# BUILDING PERMIT

Located At 314 LUDLOW ST.

Job ID: 2011-08-1874-ALTR

has permission to Construct an attached two (2) car garage/ addition.

**PERMIT SET**  
**NOT FOR CONSTRUCTION**

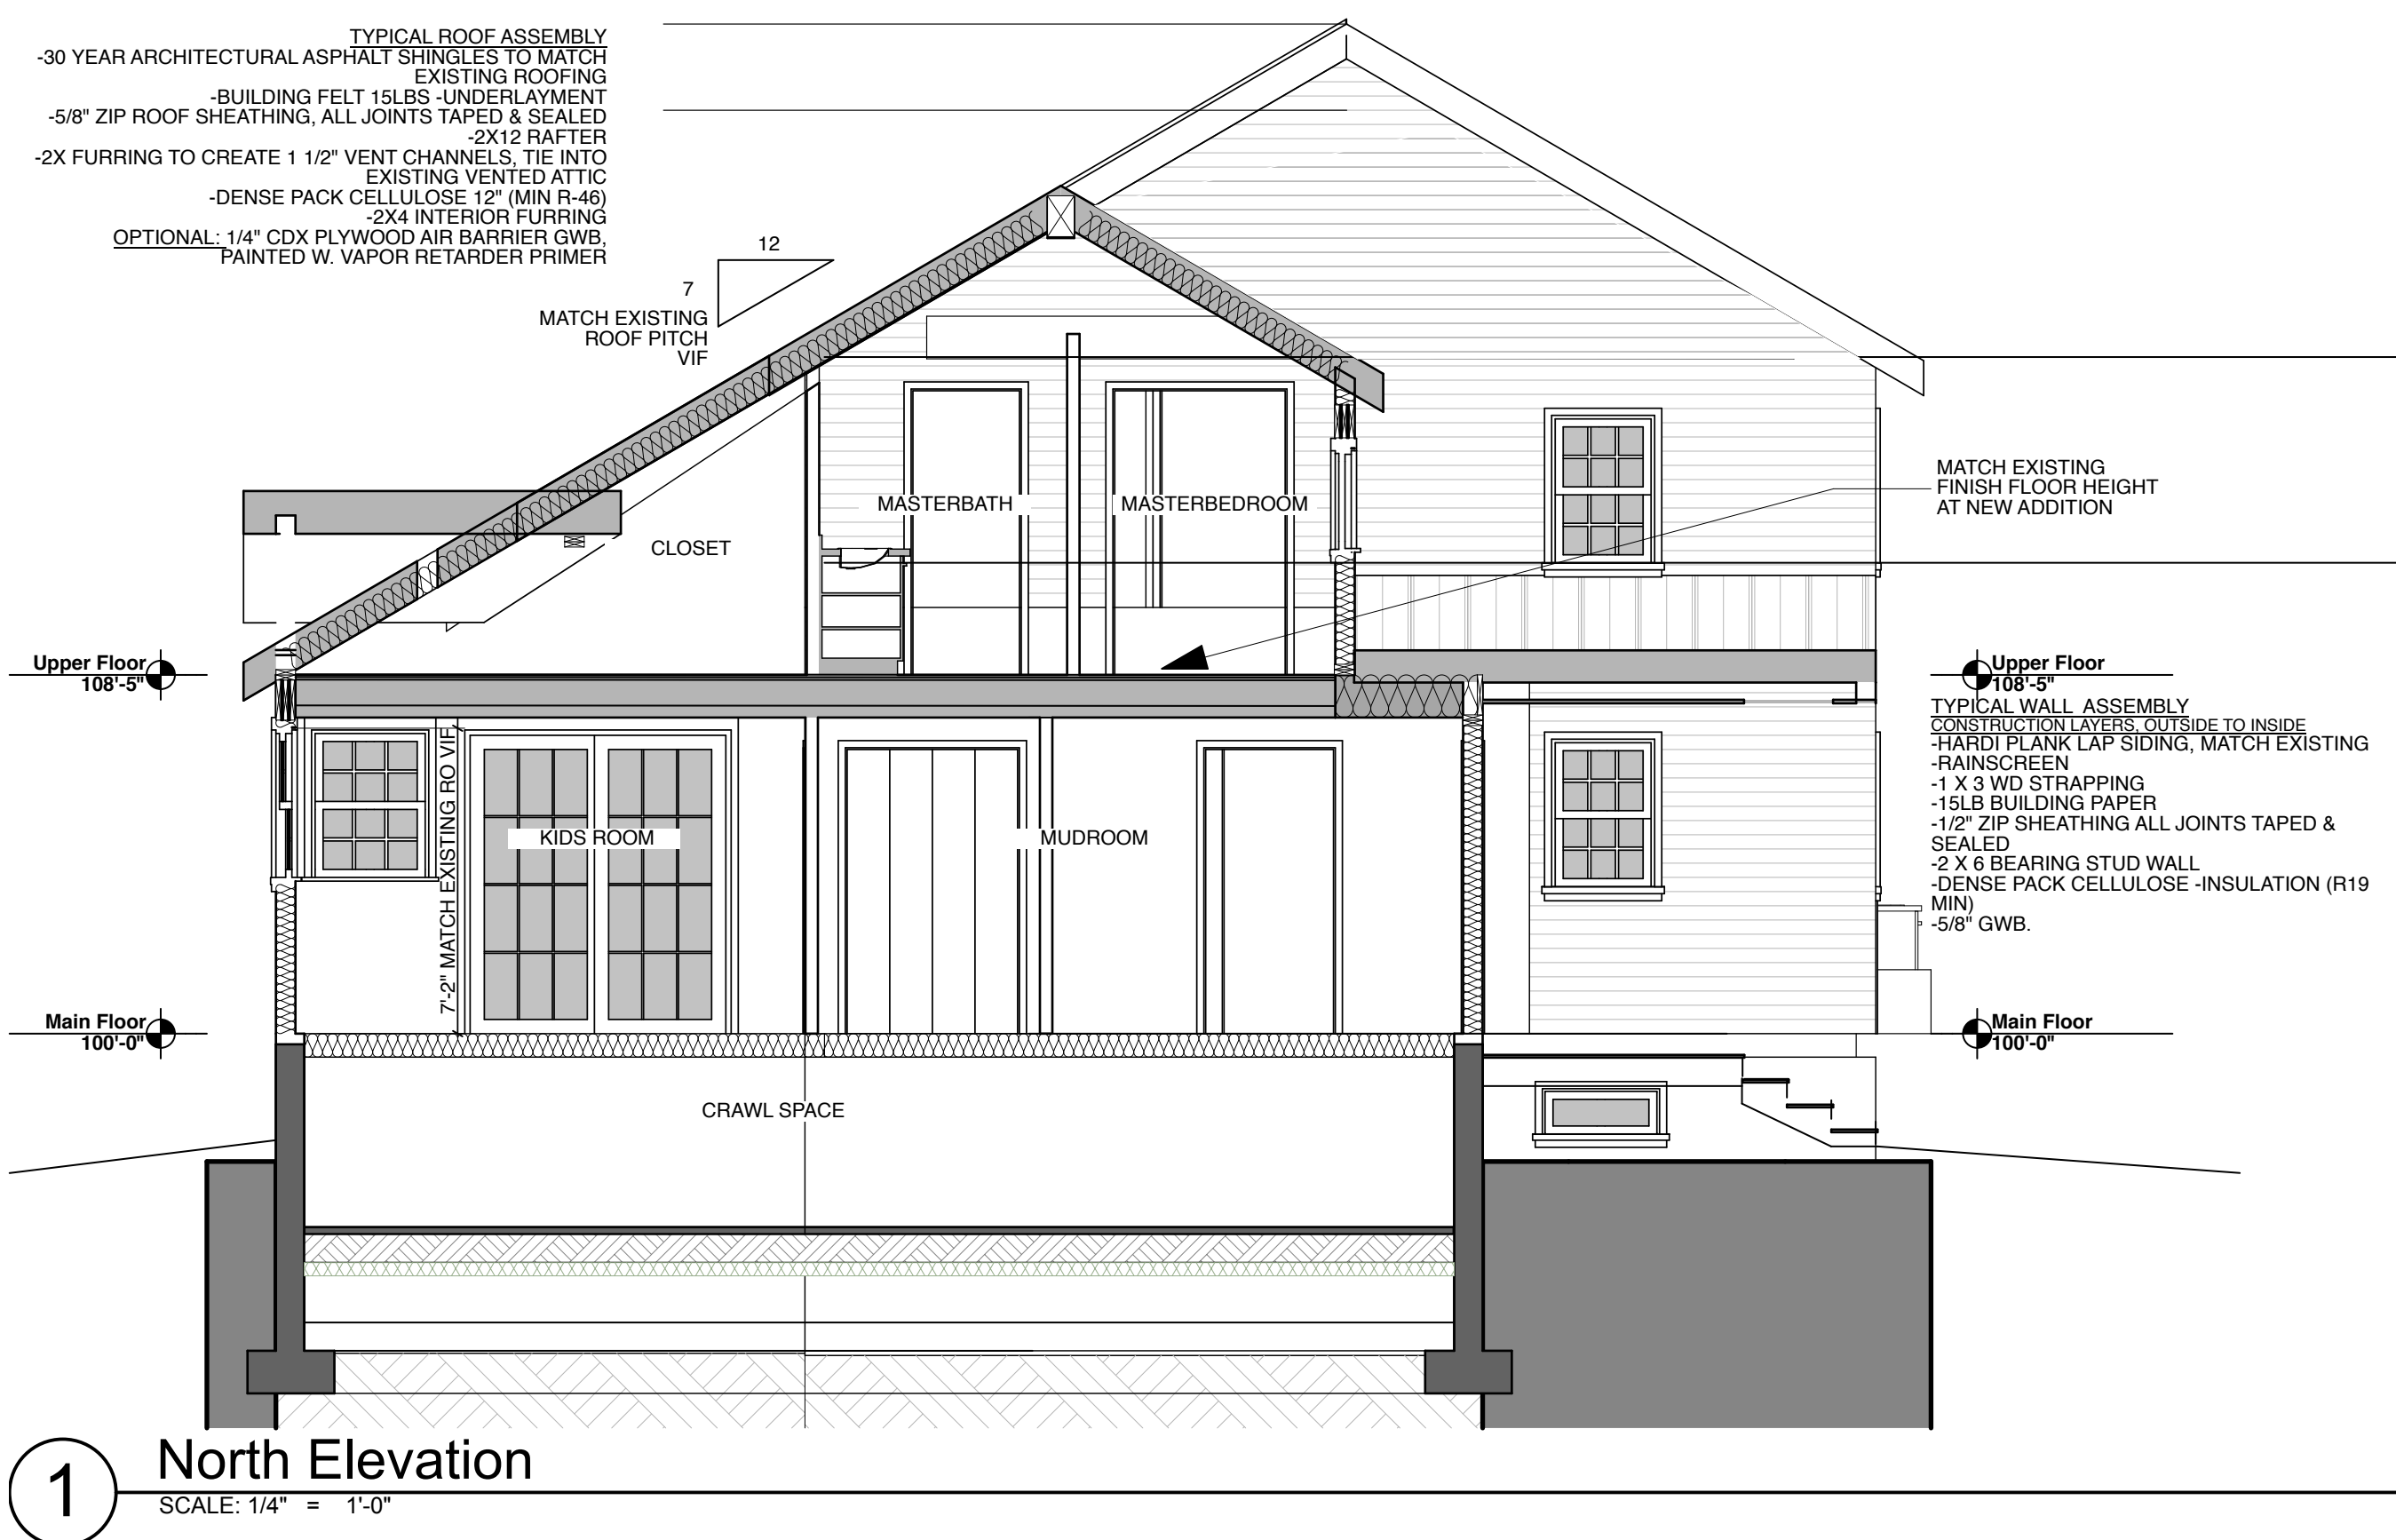
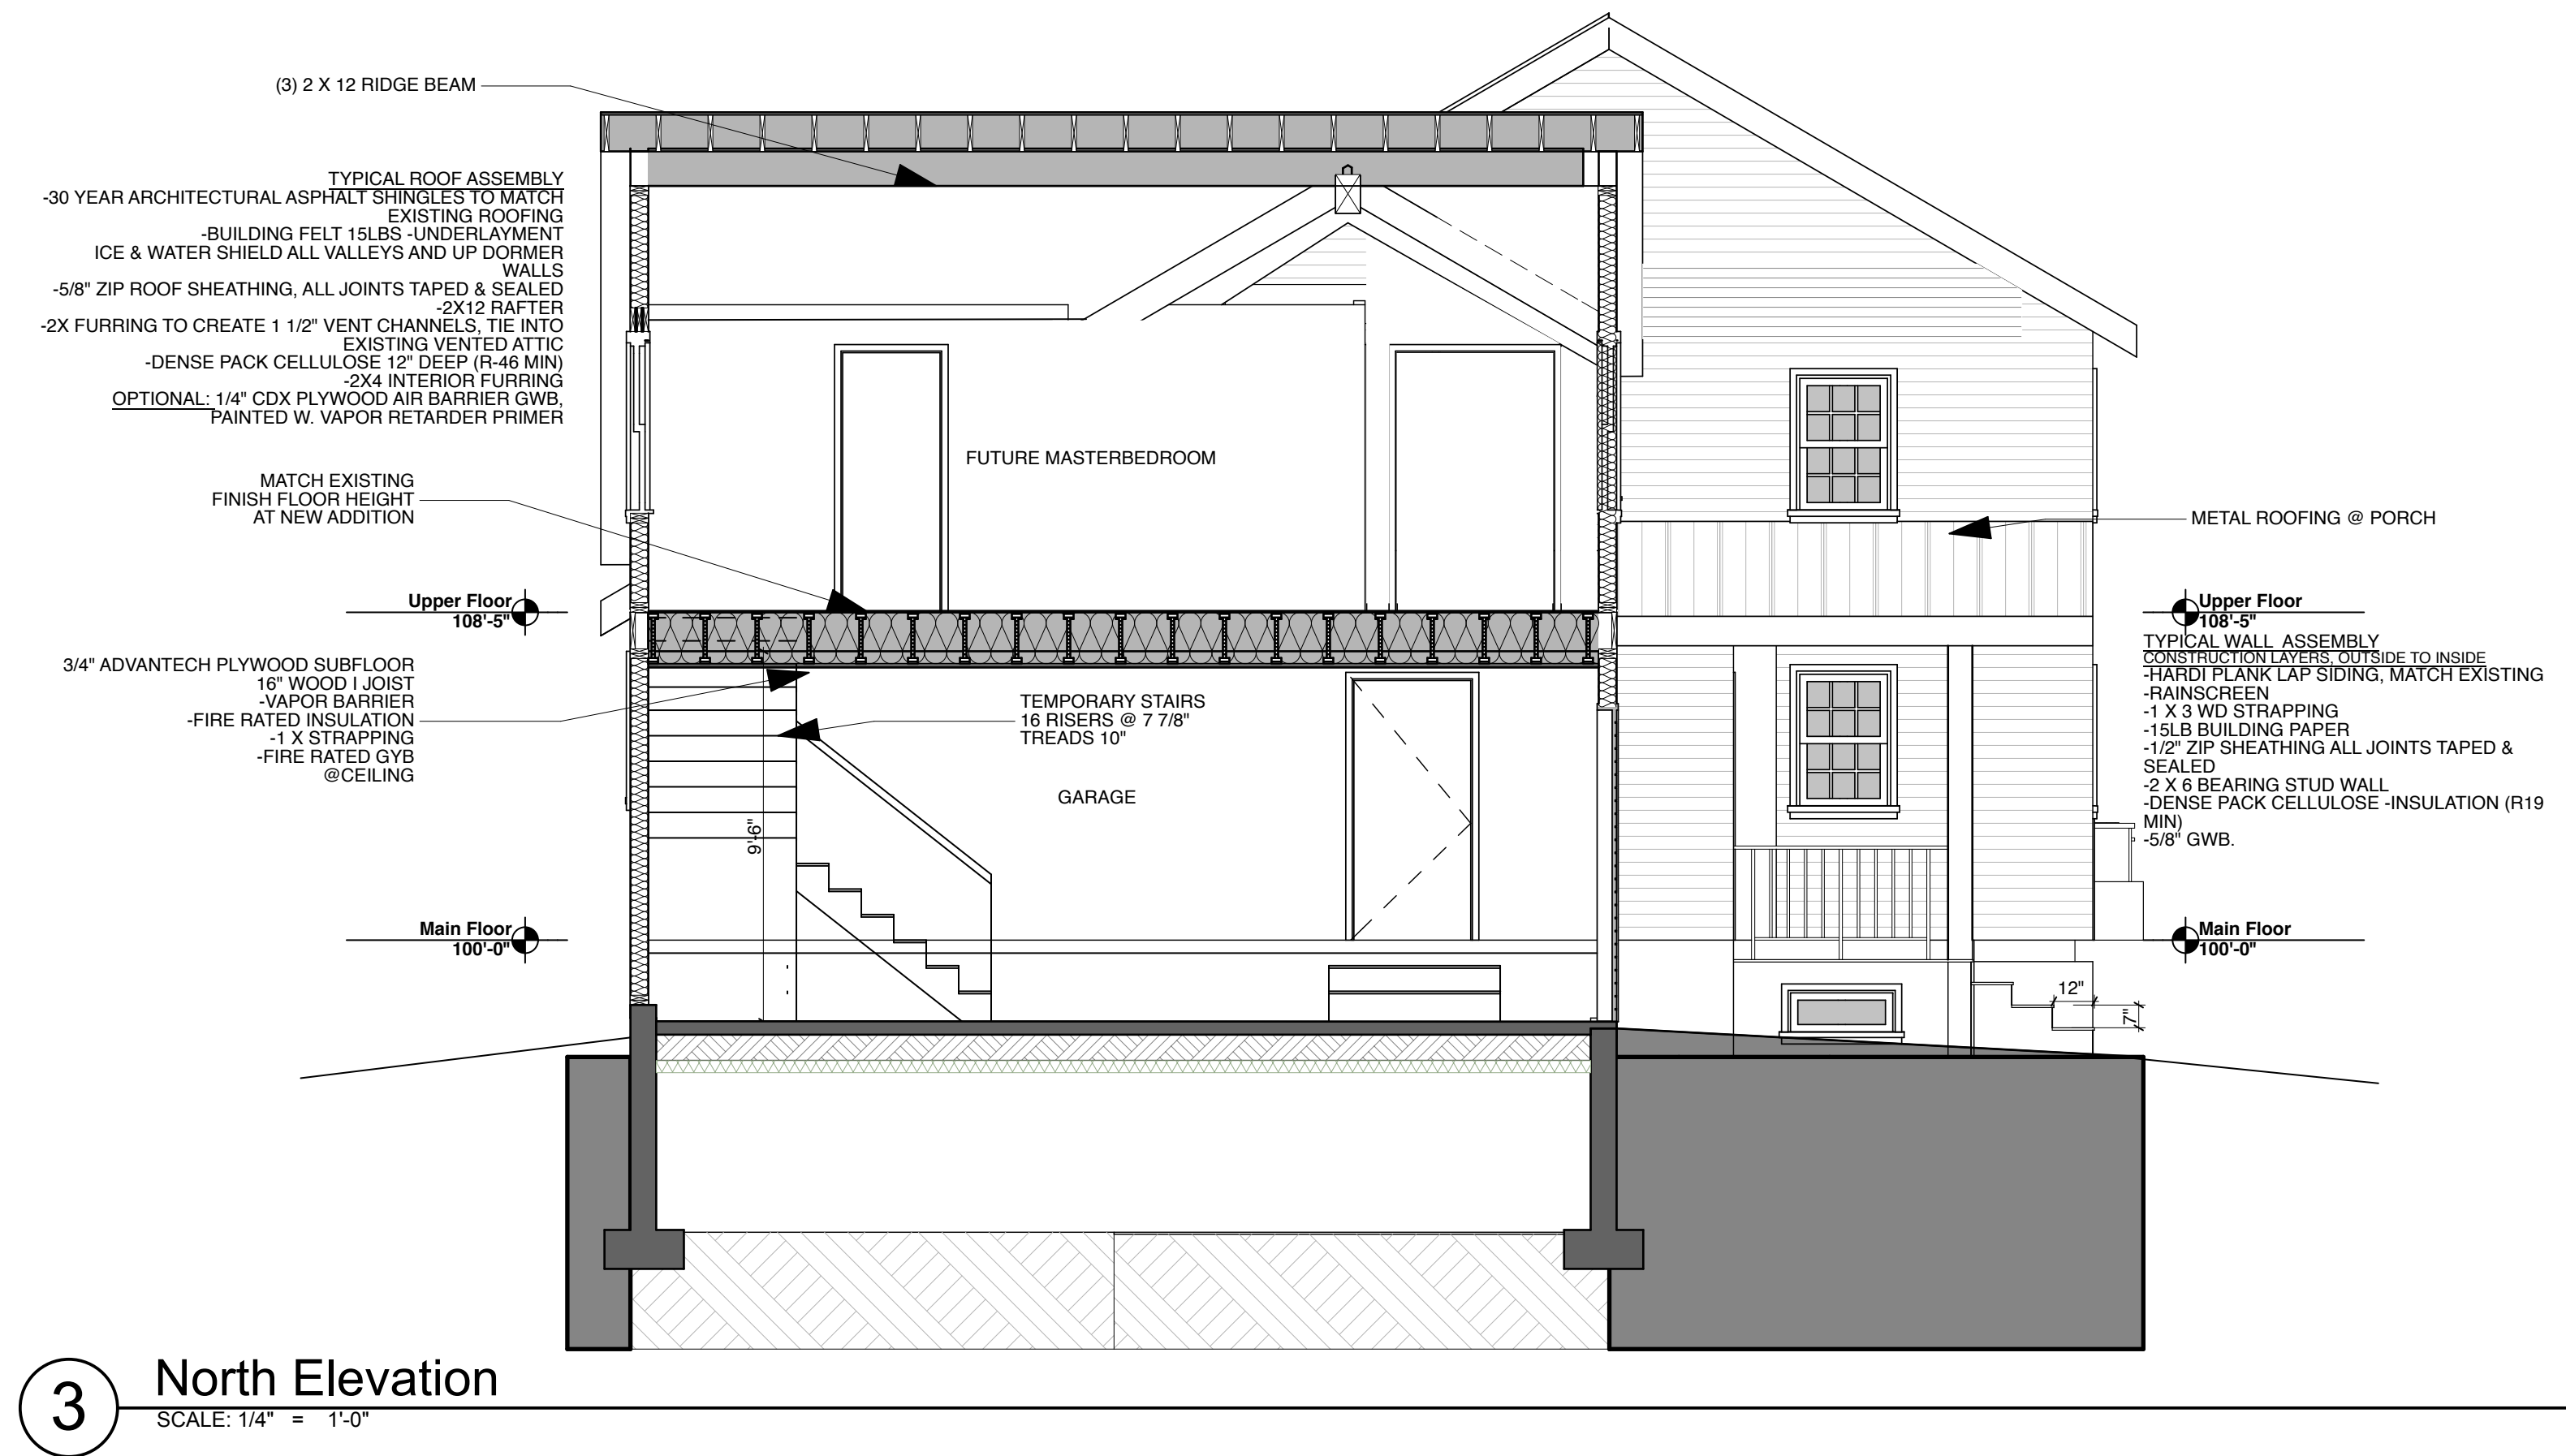
Is the (3) 2 x 12 inch Structural Ridge posted down, Or sitting on a bearing wall w/  
Lally Columns in the Garage?

- > maintain the minimal headroom from the existing second floor to new
- > floor above the garage vs the 2 X 12" @ 16" OC Rafters & (3) 2 X 12
- > Structural Beam? If not we will need a drawn cross section including the

- > Roof Rafter, Framing and connections in compliance with R802.5.1(1) &
- > R802.5.1(8) (showing finished headroom).
- >
- >
- > Are the proposed changes including the addition of any interior stairs?

> Eli,  
>  
> The elevation cannot change without Zoning review. We needs the  
> specifications (Cross-Section) on how the (3) @ x 12 inch ridge beam  
> (for the cathedral ceiling) is being posted-down to foundation. JGR.  
>  
>  
> Jonathan Rioux  
> Code Enforcement Officer/ Plan Reviewer  
>  
> City of Portland  
> Planning and Urban Development Department  
> Inspection Services Division  
> 389 Congress St. Rm 315  
> Portland, ME 04101  
> Office: 207.874.8702  
> Support Staff: 207.874.8703  
> jrioux@portlandmaine.gov  
>  
>  
> >>> <esmall2@maine.rr.com> 8/24/2011 3:11 PM >>>  
> Jon,  
>  
> Just to clarify, no stairs and no deck in the new construction.  
>  
> As for the roof, I just talked to my architect and my builder. The  
> ridgebeam that is perpendicular to Ludlow St. can be lifted to create  
> enough head room for the rafters. Based on my research of the R-3  
> building code, I have a 35' height restriction. My current roof is less

As for the roof, I just talked to my architect and my builder. The ridgebeam that is perpendicular to Ludlow St. can be lifted to create enough head room for the rafters. Based on my research of the R-3 building code, I have a 35' height restriction. My current roof is less than 24'. My builder thinks that we can lift the ridge as needed to allow for the minimum of 7' 5" interior headroom.
